REFUSAL OF PLANNING PERMISSION

APPLICATION NO. 2016/0416

Proposal Proposed cellar conversion to form 2 bedroom self-contained flat.
At 118 Park Grove, Barnsley, S70 1QE

CELLAR LEVEL
AS PROPOSED

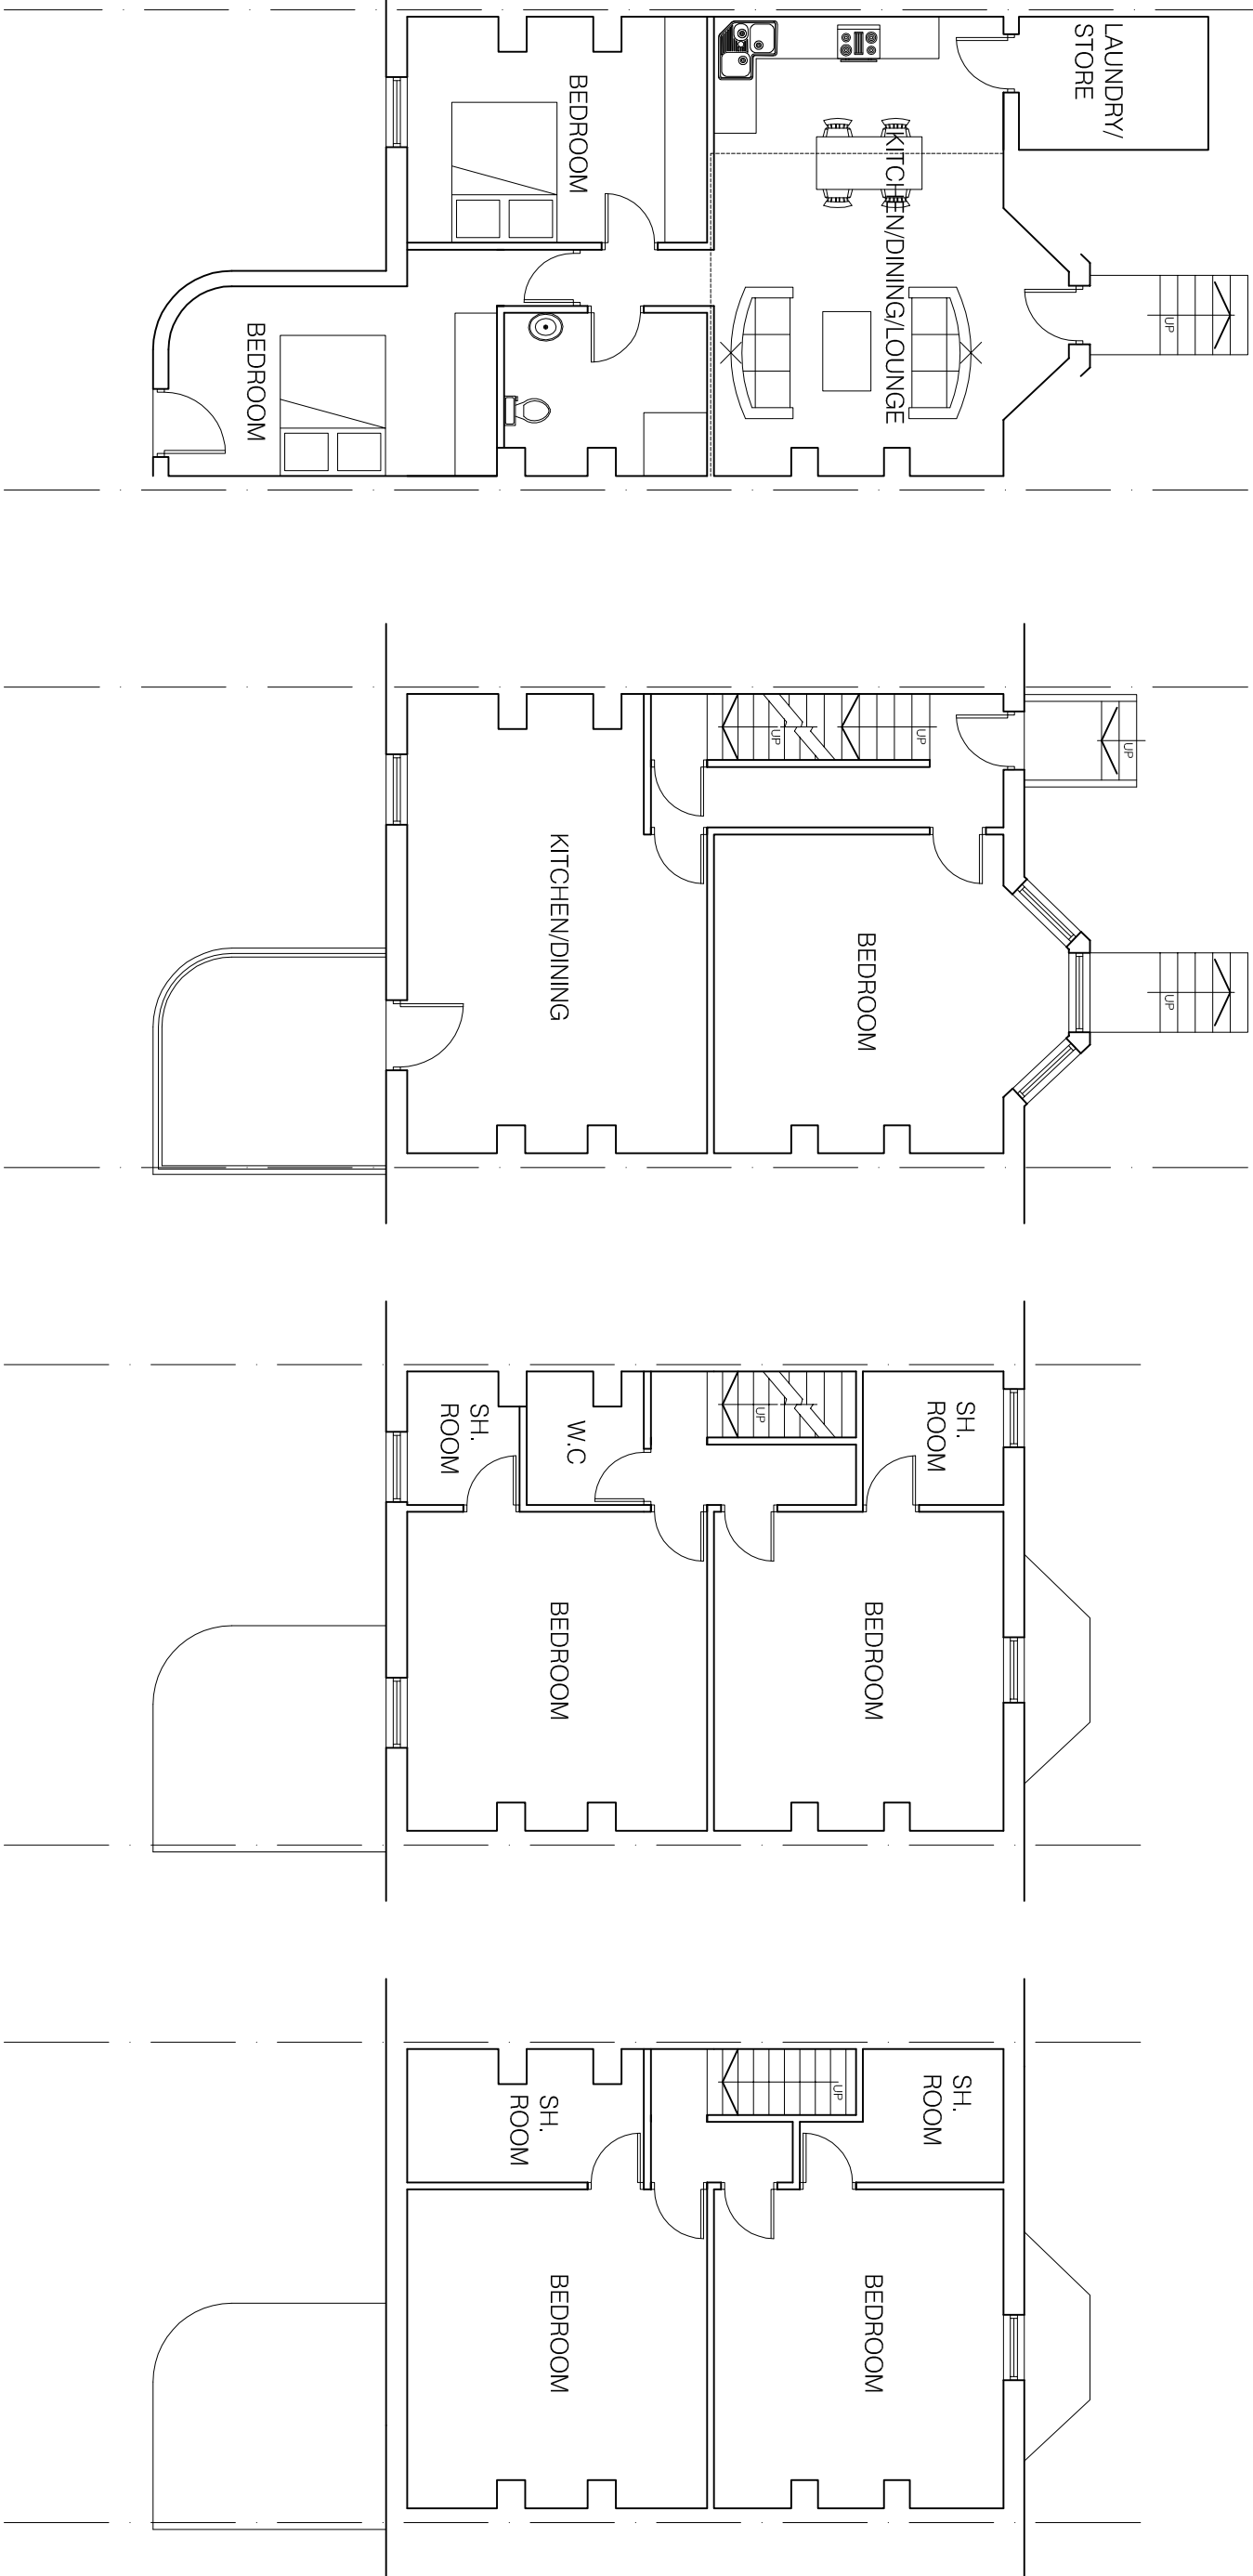
- 1 In the opinion of the Local Planning Authority, the design and layout of the proposed basement flat would form a substandard form of residential accommodation due to the compromised level of outlook, natural daylight and ventilation that it would be served with, in addition the proposals would compromise the amenity of the occupants of the host dwelling who would lose access to the rear garden area which also accommodates refuse storage. Furthermore it is also considered that the proposals would set an undesirable precedent, given that it would be the first accommodation of its kind within Park Grove, which is characterised by single occupancy dwellings. In this instance it is considered that the alterations to the property and associated increase in activity to the dwelling would have a detrimental impact on the character of the area. For these reasons it is considered that the proposal would be contrary to Supplementary Planning Document 'Designing New Housing Developments' the South Yorkshire Residential Design Guide and Core Strategy policy CSP29 'Design'.
